### RE: Green Pasture Short Plat (SP-08-00053)

The Kittitas County Community Development Services Department has determined that the Green Pasture Short Plat (SP-08-00053) is a complete application and hereby grants *conditional preliminary approval* subject to the following conditions:

GREEN PASTURE SHORT PLAT

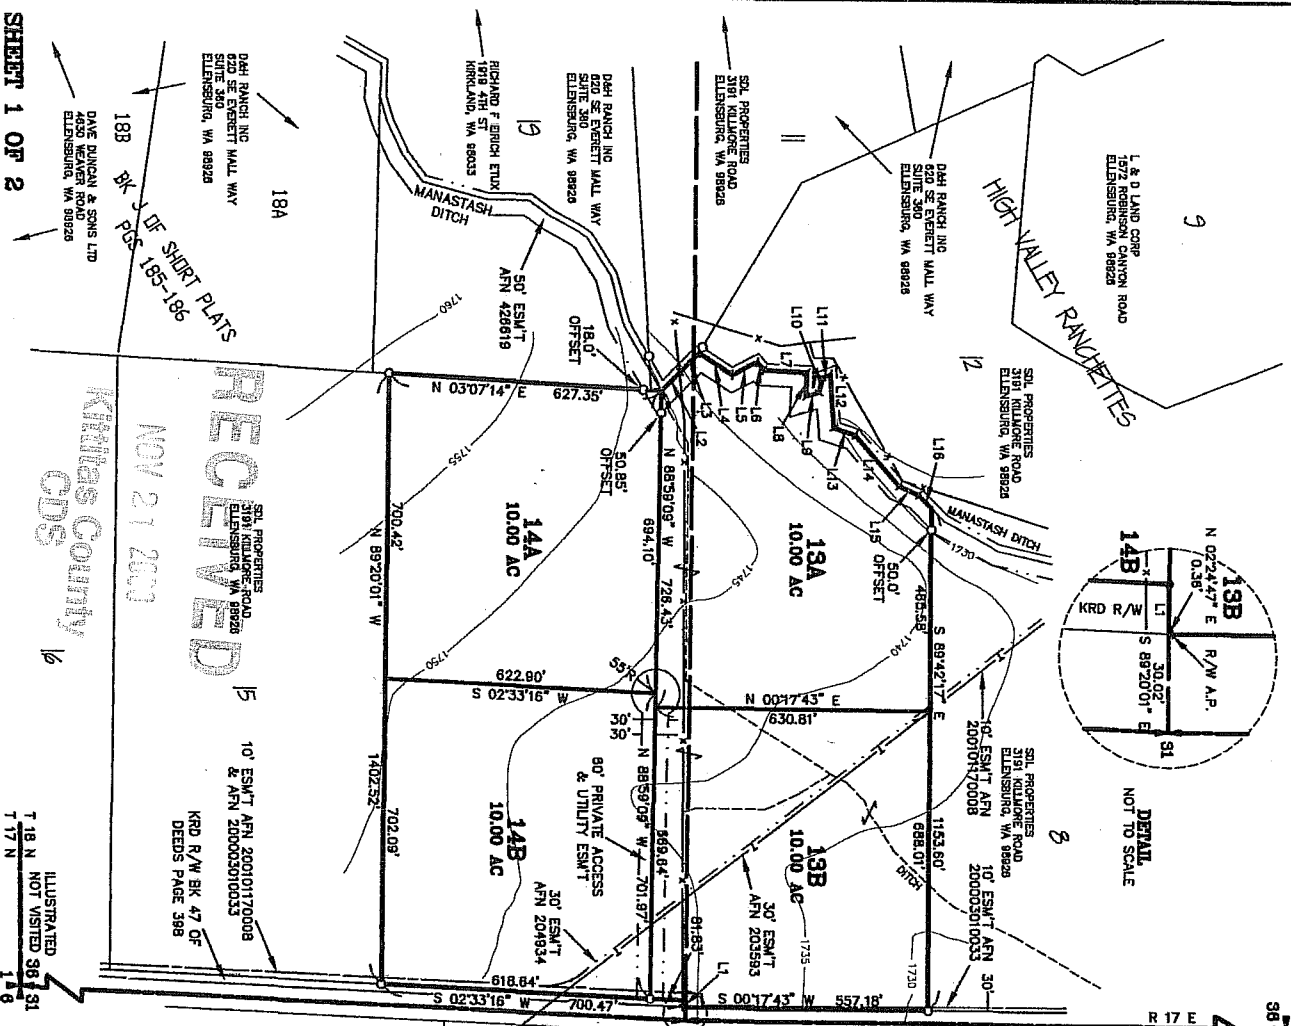
1. Both sheets of the final mylars shall reflect short plat number SP-08-00053 and an accurate legal description shall be shown on the face of the final plat.

6. Lot 14B of the Green Pasture Short Plat has a PEMC wetland across the northwest corner of the property. The Final mylars shall reflect the location of this wetland and a statement on the plat shall read as follows: "Future development of lots may require a study by a certified wetland biologist to determine wetland classification and for buffer requirements pursuant to KCC Critical Areas Code."
